From: Anita Gardner
Sent: 08 June 2018 15:51
To: Planning.Responses
Subject: FW: FG/48/18/DOC Onslow Caravan Park, Ferring

The Drainage Engineer has stated relating to Condition 4 Drainage:

The Drainage Engineer has stated relating to Condition 4 Drainage:

Scale 1:250 Date 03.11.17 Drawing No 100 A

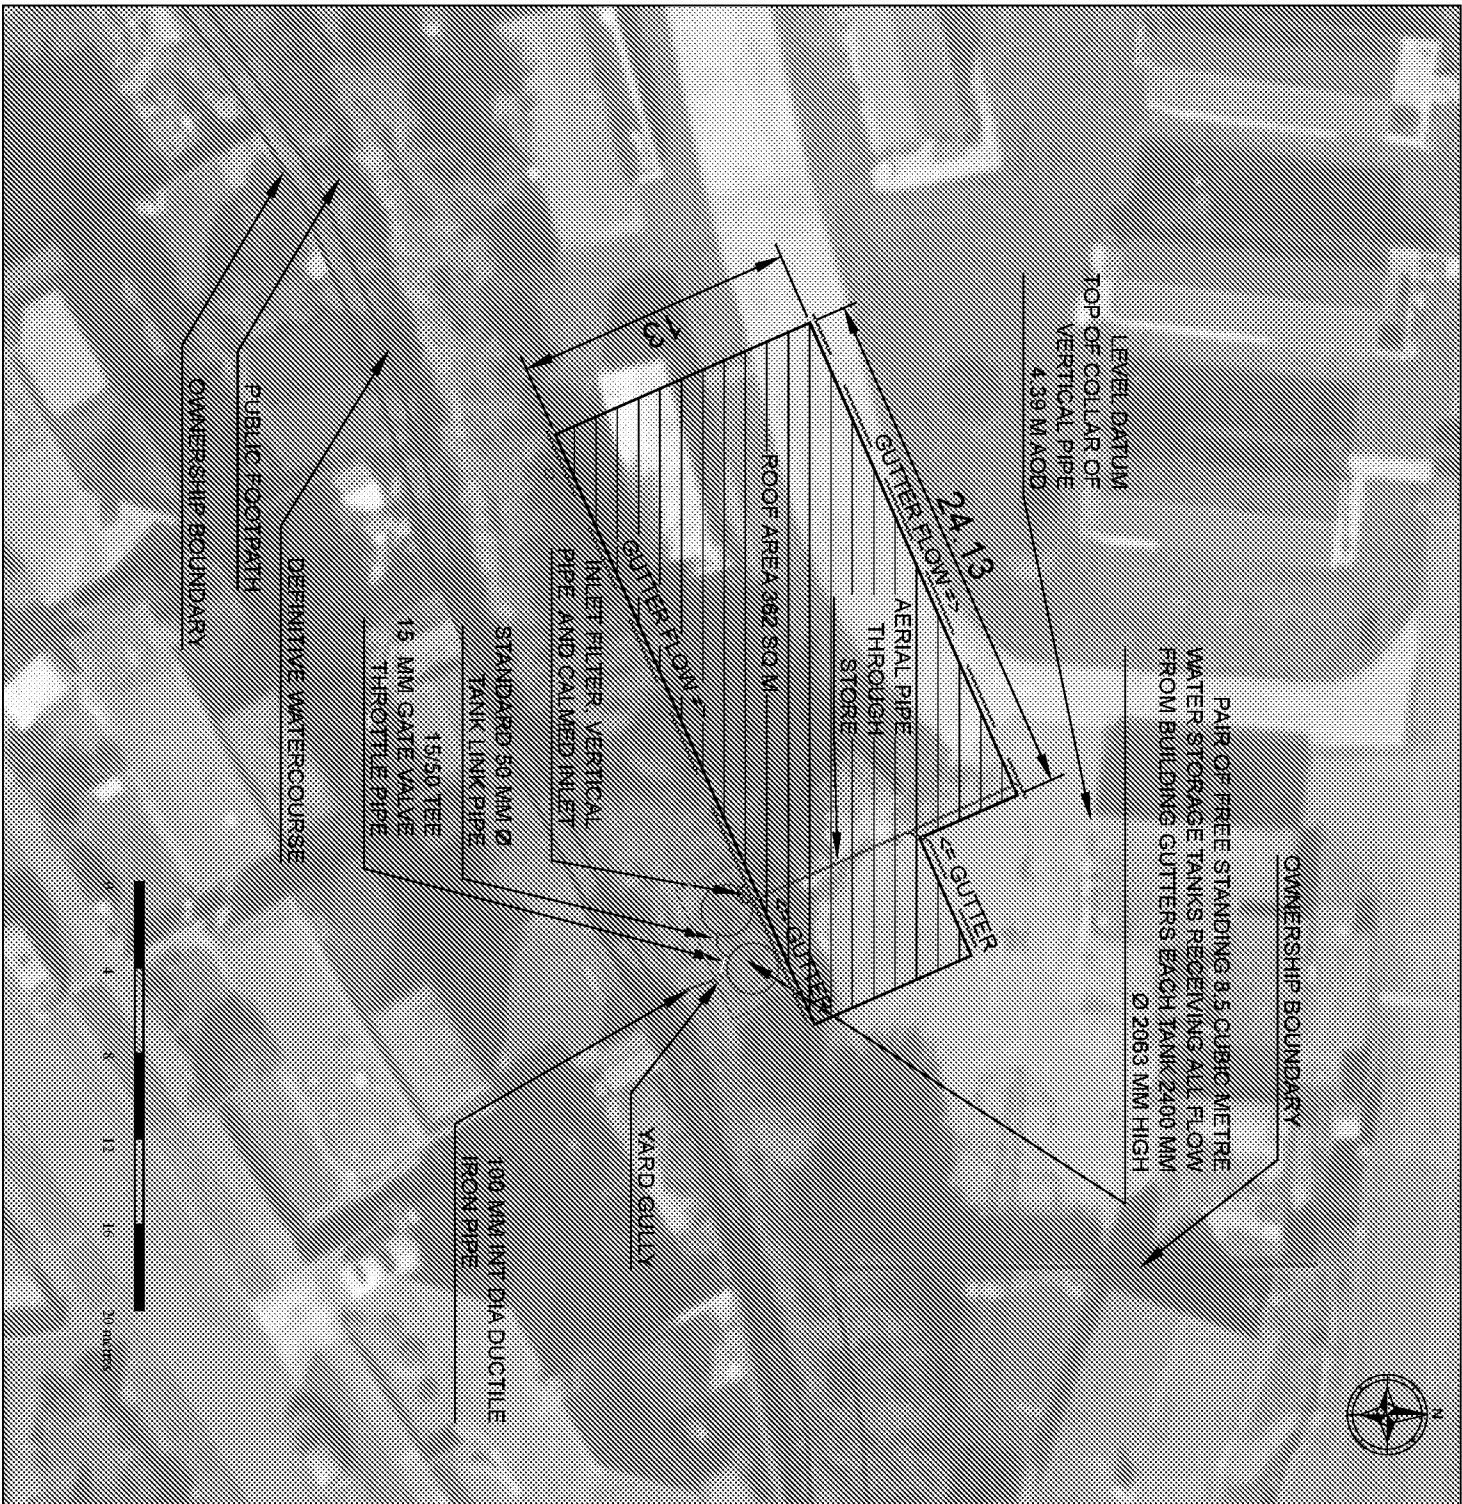
- The restriction size of 20mm is of concern regarding the possibility of blockage. It is recommended that a mesh or similar is installed within each tank at the face of the outlet. THE INLET STRAINER IS SUPPLIED TO PREVENT LARGE PARTICLES ENTERING THE TANKS. FLOW RATES THROUGH THE OUTLET ARE SO LOW THAT IF GROWTH OCCURS WITHIN THE TANKS, IT WOULD NOT TEND TO BE DRAWN TOWARDS THE OUTLET, WHICH HAS THE ABILITY TO PASS 1.5 MM PARTICLES. IF A BLOCKAGE WERE TO OCCUR, IT WOULD SPOTTED QUICKLY AND WOULD BE EASY TO REMOVE. WHEREAS THE TEE COULD BE CHANGED AND A 1. 1/2" BSP STRAINER ADDED, ALLOWING EASY MAINTENANCE, SUCH A STRAINER IS LIABLE TO BLOCKAGE WITH SMALL PARTICLES. THEREFORE NO STRAINER IS RECOMMENDED. A MESH SCREEN WITHIN THE TANKS AS SUGGESTED WOULD BE VERY DIFFICULT TO MAINTAIN AND THUS ALSO IS NOT RECOMMENDED. OKAY. HOW FREQUENTLY WILL THE INLET STRAINER BE INSPECTED AND CLEANED?

- It is currently proposed that the outlet to the existing ditch will be formed by a paving slab. This is not acceptable, we require a formal headwall to be formed using concrete bags or brickwork. With full construction detail drawings

to be supplied and approved by us. THE OUTLET PIPE IS DUCTILE IRON WITH A FLAP ATTACHED. AS SUCH THE OUTLET IS RESILIENT TO DAMAGE AND BARELY ANY DISTURBANCE OF THE BANK WILL OCCUR. A HEADWALL IS ENTIRELY UNNECESSARY. THE PROPOSED PAVING SLAB CAN BE OMITTED. A HEADWALL IS REQUIRED TO ENSURE THAT THE CONTINUED IDENTIFICATION AND MAINTENANCE OF THE OUTLET IS EASY. OUTLETS WITHOUT HEADWALLS ARE FREQUENTLY LOST AND MAINTENANCE OF THE DITCH IS MORE DIFFICULT. THEREFORE, A HEADWALL WILL BE REQUIRED.

- Full construction details will be required including the gully/headwall, any manholes, and silt traps. DRAWING 100A ALREADY SHOWS EVERY DETAIL NECESSARY TO BUILD THE UNDERGROUND DRAINAGE. NO OTHER DETAIL COULD BE REQUIRED. PLEASE PROVIDE CONSTRUCTION DETAILS OF THE GULLY AND HEADWALL.

- It is noted that only a 20% allowance for climate change has been included in the design of the surface water drainage system. This needs to be increased to 30% in line with the condition applied.
- Storm durations from and including 15 minutes need to be used.
- The restriction size of 20mm is of concern regarding the possibility of blockage. It is recommended that a mesh or similar is installed within each tank at the face of the outlet.

- It is currently proposed that the outlet to the existing ditch will be formed by a paving slab. This is not acceptable, we require a formal headwall to be formed using concrete bags or brickwork. With full construction detail drawings to be supplied and approved by us.
- Full construction details will be required including the gully/headwall, any manholes, and silt traps. I would therefore appreciate receipt.

I amended the drainage details to address Arun's comments, and incorporated them in a contiguous file for approval by the LPA. All previous drainage details are superseded.

1. A brick headwall is specified as required. The exact length of the raking wing walls should be adjusted to match the local bank profile, but as drawn it will be close based on site photographs. The height matches levels taken.

2. The gully hasn't been redrawn, but an enlarged detail is shown for clarity.
3. The ductile iron pipe is retained, but is surrounded with a minimum of 100 mm of concrete to seal the trench.

4. The maintenance interval for the filter, six months, was given in the notes of the plan, and hasn't been changed.
5. 30% climate change has been allowed for. The tank sizes are unaltered, but the revised storage calculation uses a slightly higher peak discharge at tank full, 0.62 litres per second, reflecting the previous throttle rating calc, which has not changed. The average discharge rate in the critical duration 100 year climate changed storm is only 0.4 litres per second, which is low.
